YorkshireWater

Your Ref: 2021/92086

29th June 2021

Land at Bradley Villa Farm, Bradley Road, Bradley, Huddersfield – Erection of 270 residential dwellings and associated infrastructure and access

MARKETING NAME		-	
PROJECT		BRADLEY VILLA FARM HUDDERSFIELD	
TITLE		PROPOSED DRAINAGE LAYOUT OFF SITE SHEET 2 OF 2	
SCALE @ A1:	DESIGN/DRAWN:	APPROVED:	DATE:
1:500	MML	KL	MARCH 2021
PROJECT No:	DRAWING No:	REV:	
4607	4607-16-06-902	C

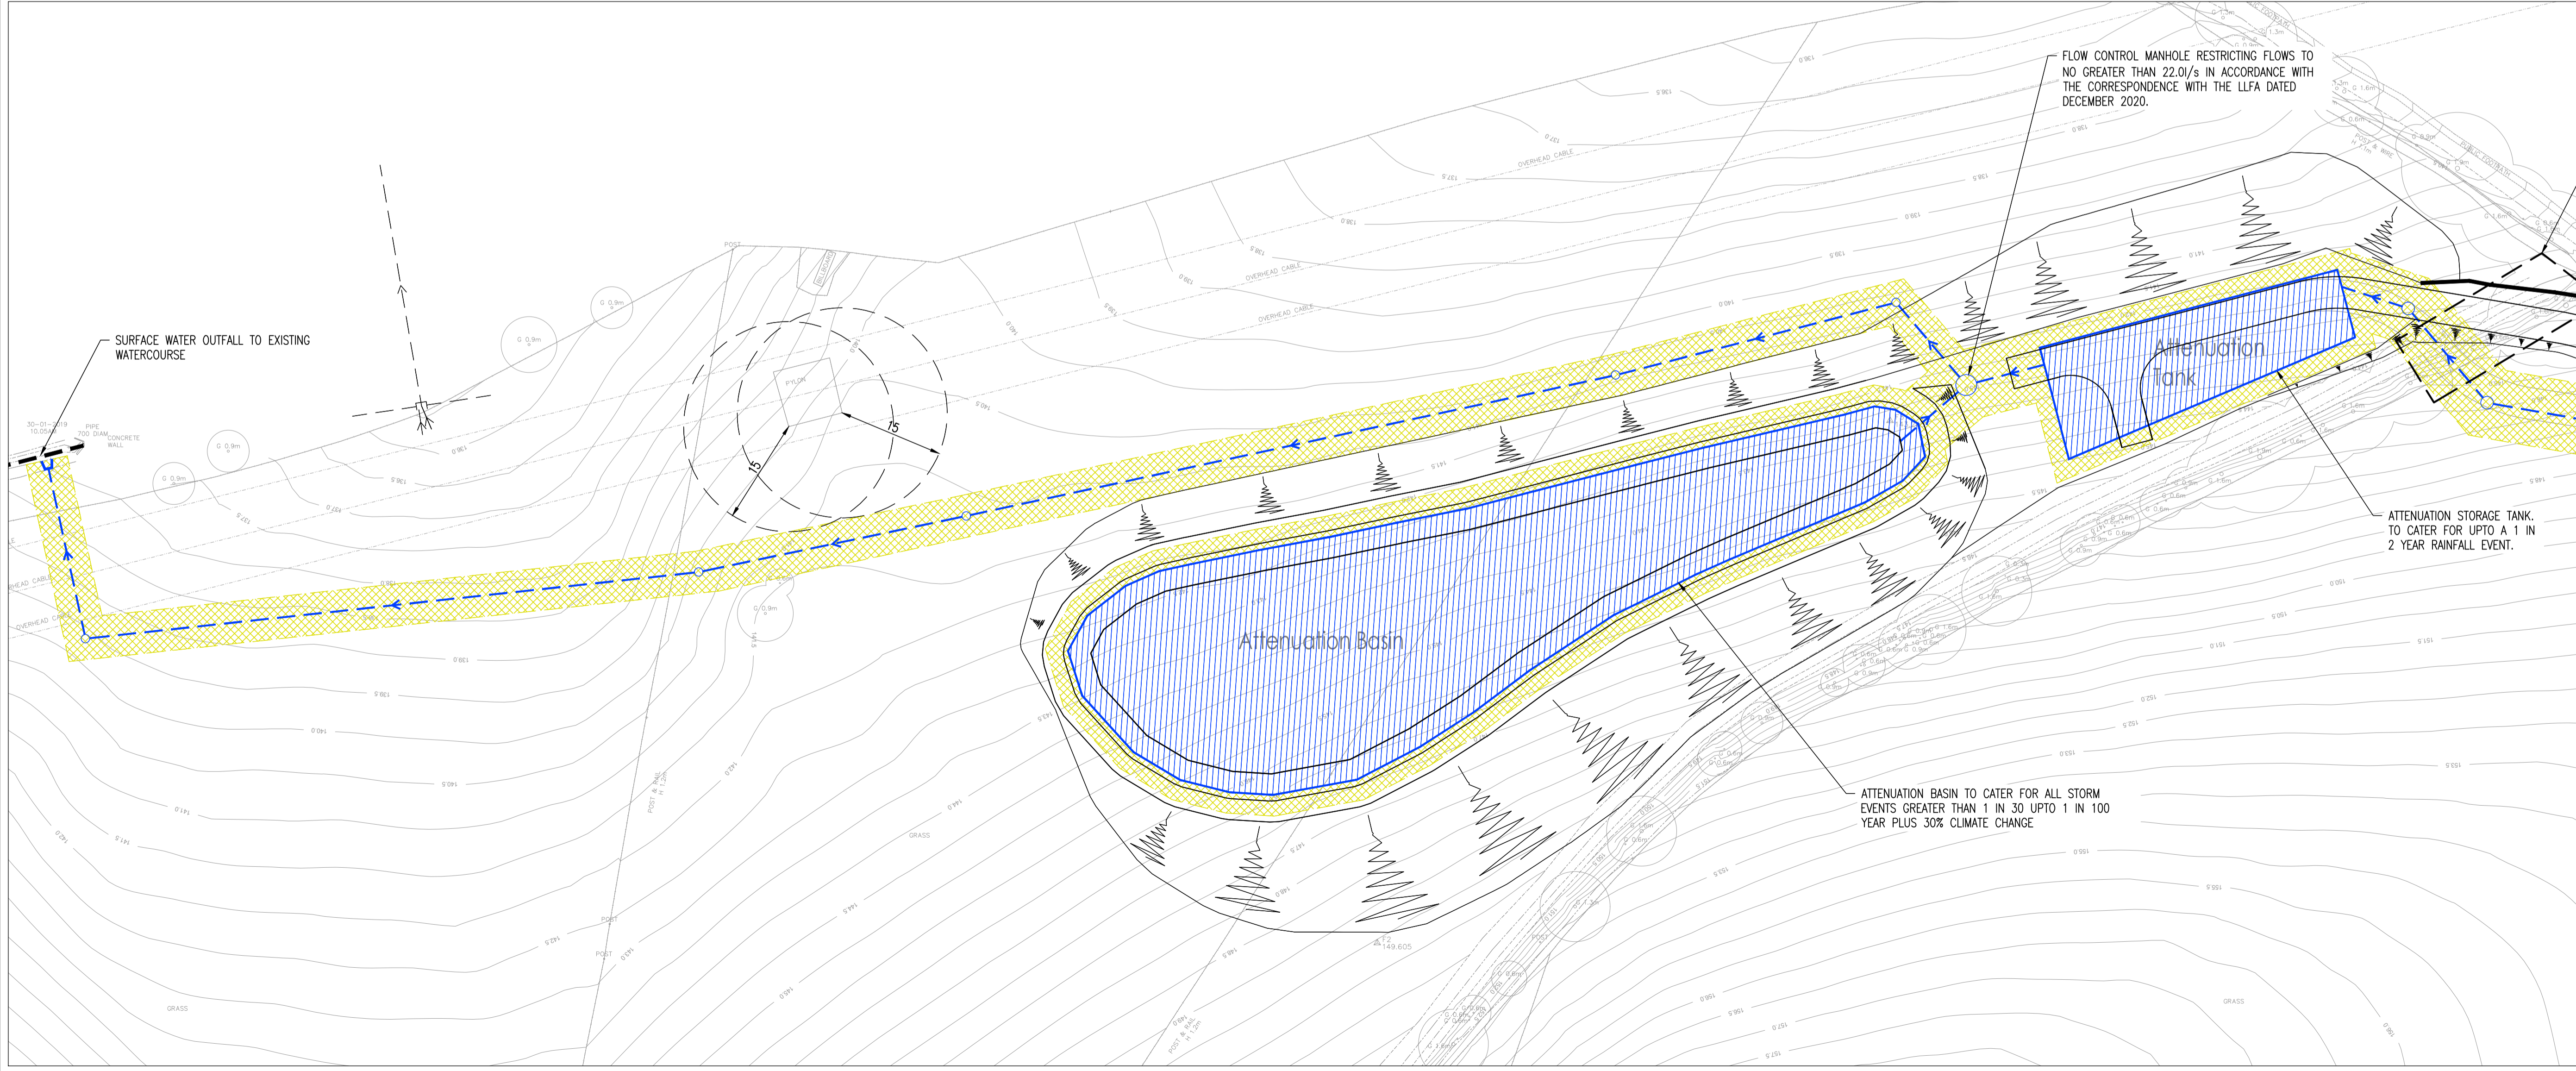
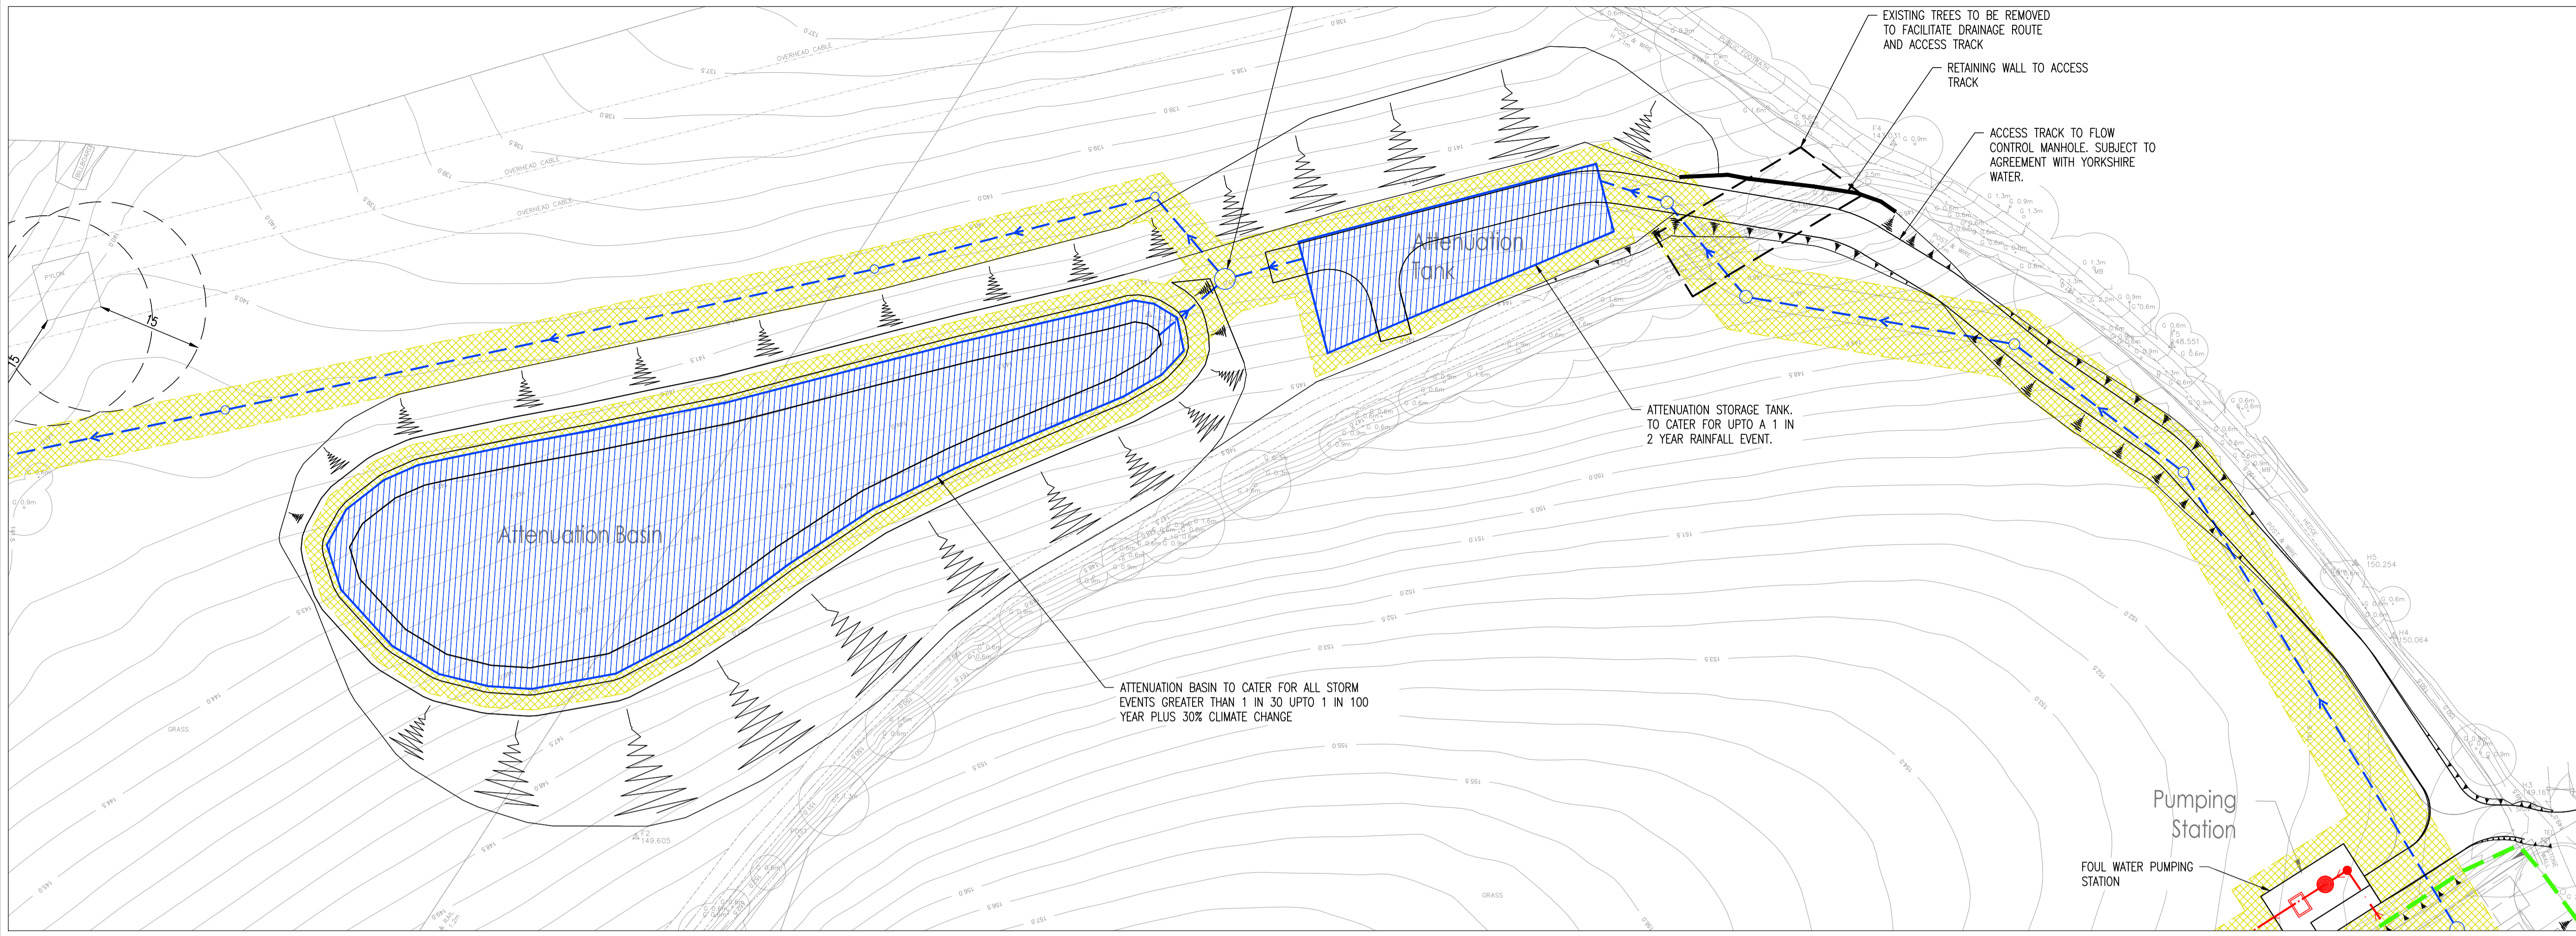
We have no objection to the proposal to connect to the 450 mm diameter public combined sewer in Bradley Road via gravity, to the south of the site. For the proposed foul water pumping station within the site, the peak pumped foul water discharge must not exceed 4.75 (four point seven five) litres per second.

The site shall be developed with separate systems of drainage for foul and surface water on and off site. The separate systems should extend to the points of discharge to be agreed. The maximum foul water pump rate shall not exceed 4.75 (four point seven five) litres per second.
